From: Anita Gardner <Anita.Gardner@arun.gov.uk>
Sent: 15 July 2020 12:18
To: Planning.Responses <Planning.Responses@arun.gov.uk>
Subject: FW: LU/149/20/PL - Sculpture, Littlehampton Wave

From: Anita Gardner
Sent: 03 July 2020 13:57
To: Karen Liu <Karen.Liu@arun.gov.uk>
Subject: LU/149/20/PL - Sculpture, Littlehampton Wave

Drawing Title:
Plan & Elevation of Sculpture
Concrete Plinth

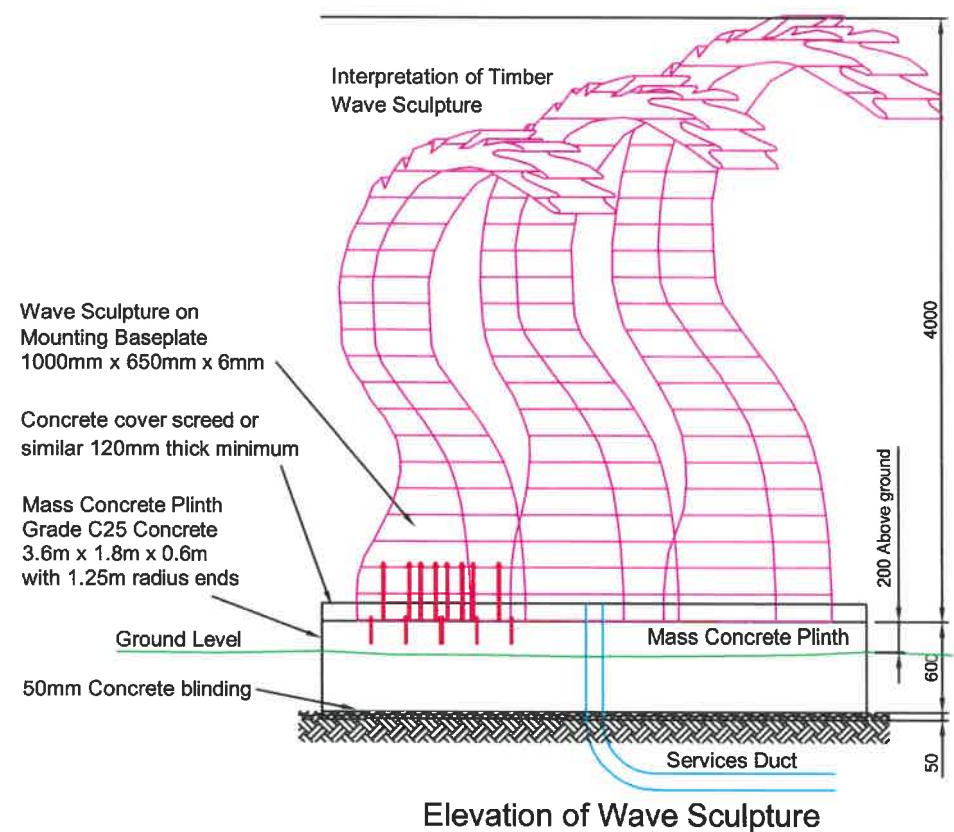
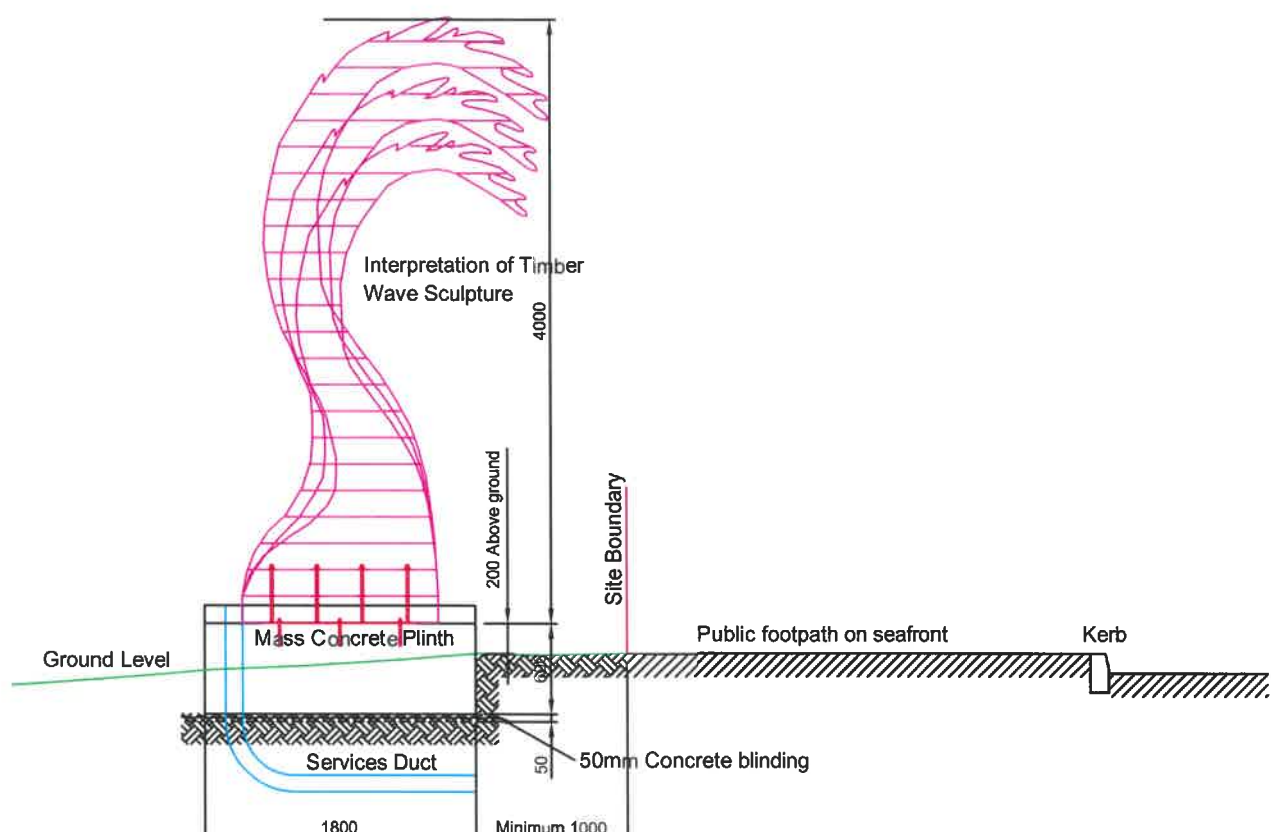
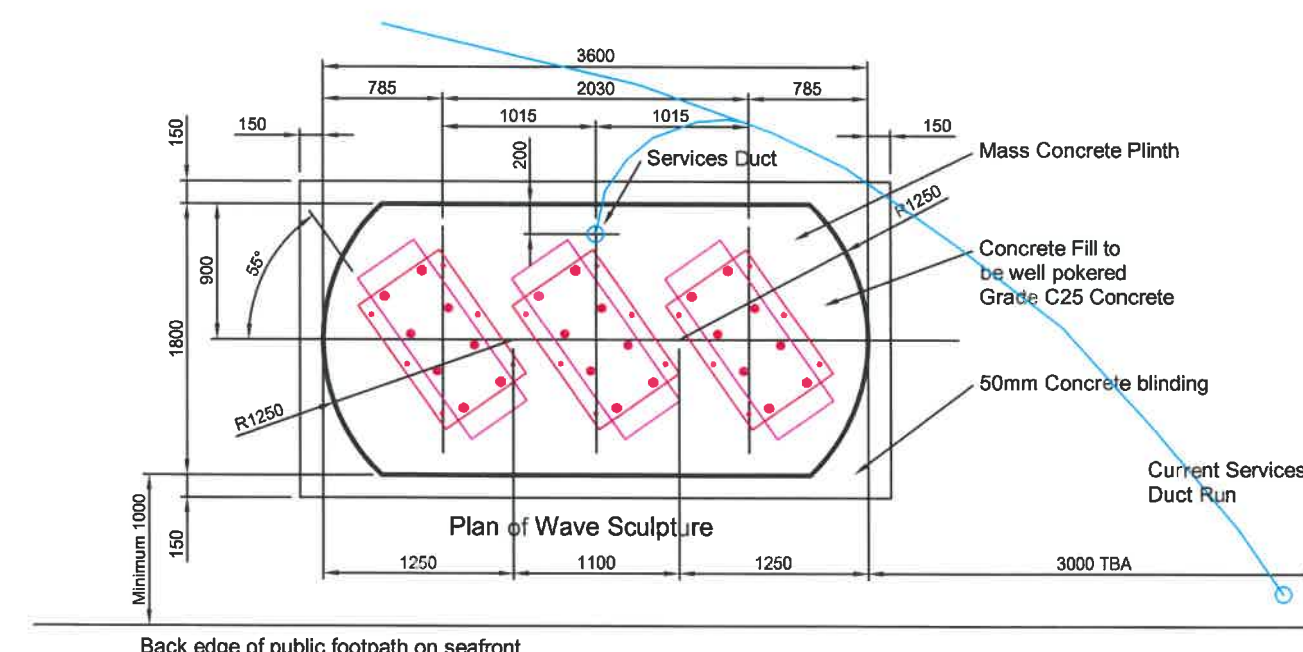
- Is the sculpture is going to be illuminated? There is no mention of it. Bearing in mind where it is and what it supposed to be doing I would suggest this should be considered.
- Is it intended that the plinth would be painted? It would be much better if it were painted to fit in with the grass verge in which it sits. A big grey slab in this setting would be prominent. Does the slab need to be so large?
- The plan of the structure is completely different to the photo image which doesn't seem a true representation. Can you provide clearly labelled scaled elevations for each side of the sculpture and maybe other photo montages from other directions further away from the base of the structure.
